From: Laura Gibbons
Sent: 20 August 2018 11:47
To: Planning.Responses
Subject: RE: Planning Consultation on: AL/84/18/DOC

Engineers Comments Regarding Condition 3- Surface Water Drainage

APPLICATION NO: **AL/84/18/DOC**

Description of Works: Approval of details reserved by condition imposed under AL/105/16/HH relating to condition 3-surface water drainage.

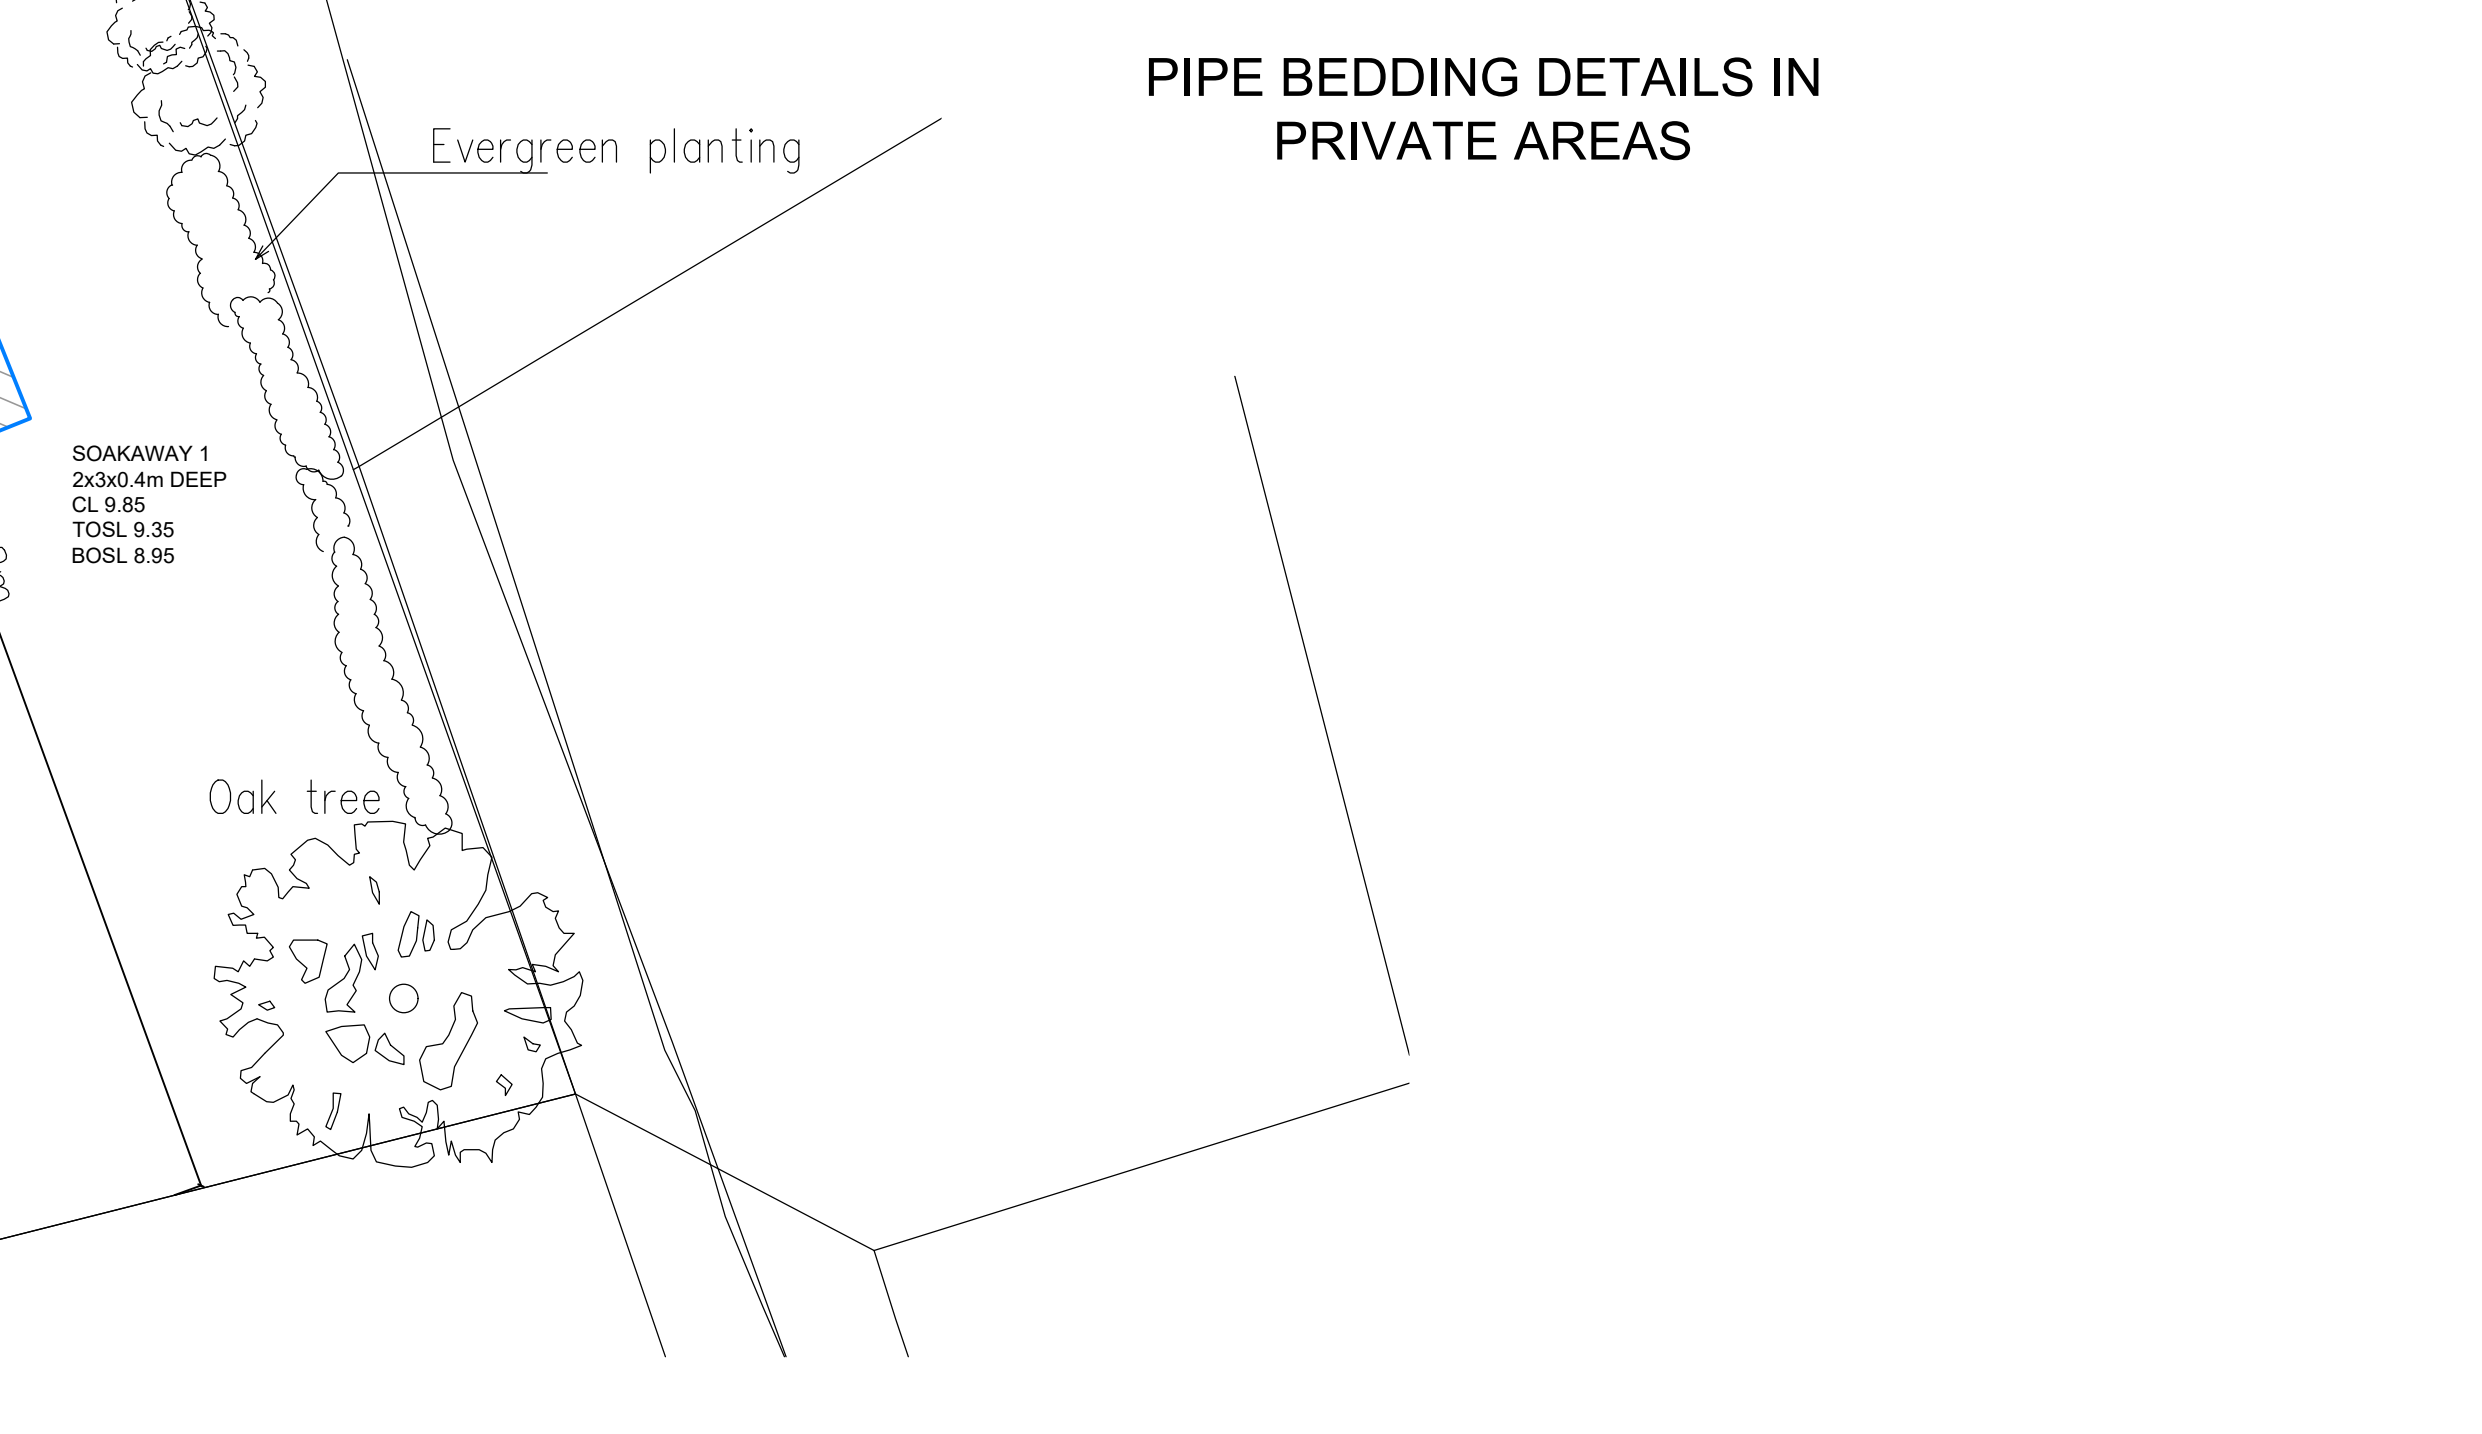
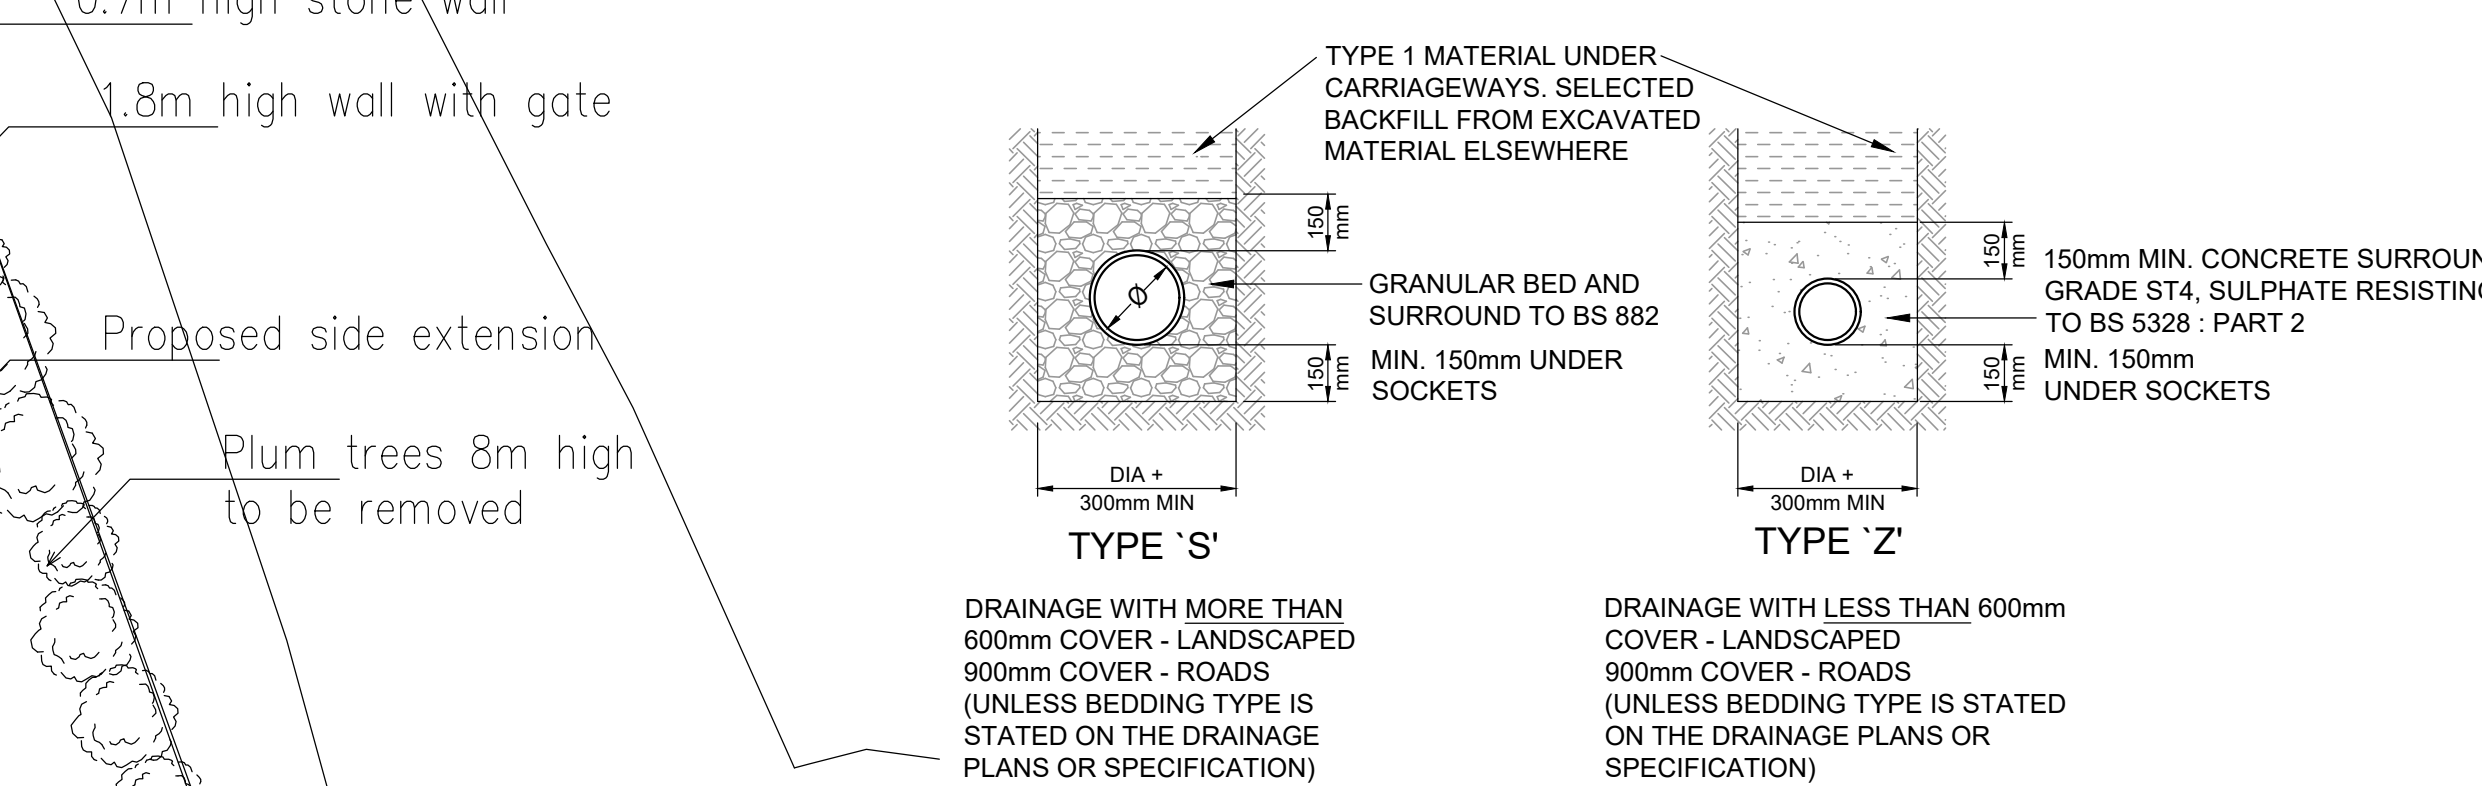
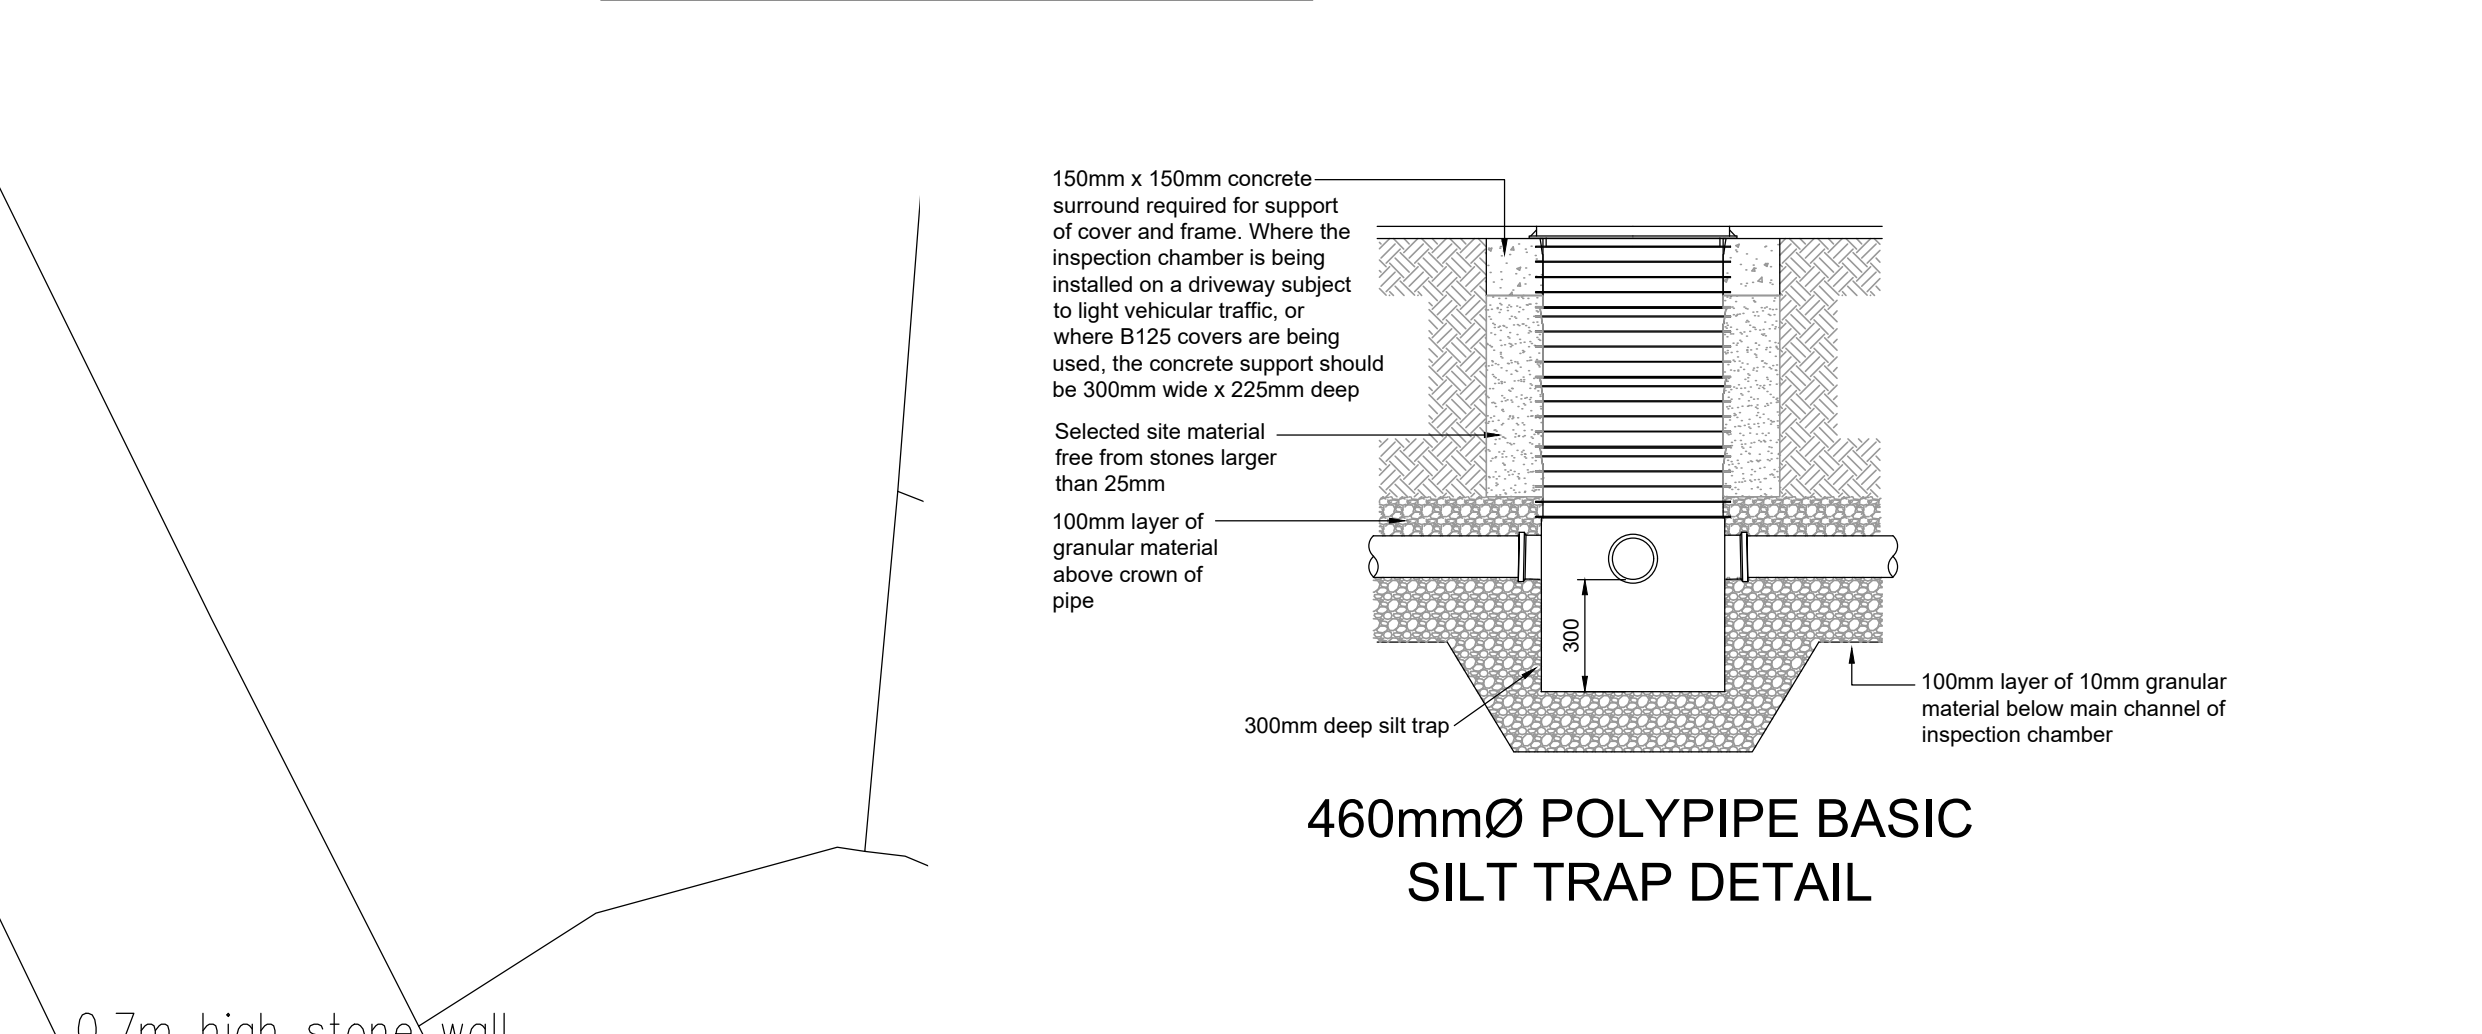
1. The provided details state that the soakaway crates are to only be used in landscaped areas, yet they are being used under an area of driveway. Please clarify if the crates to be used and cover details are sufficient to take loading from vehicles.
2. The incoming pipes to soakaways should be located as high in the soakaways as possible. Can any adjustment be made to the design to ensure the pipes come in at a higher level, but that the base of the infiltration structures is set no lower than 1m.
3. Please provide details for the pipe cover details to ensure these meet building regulation requirements. I.e. concrete bed and surround where cover depths are limited.
4. Please also specify pipe invert levels, diameters, and slopes on plan.
5. No calculations were provided, but my own checks completed on the soakaway dimensions demonstrate that sufficient area has been provided.
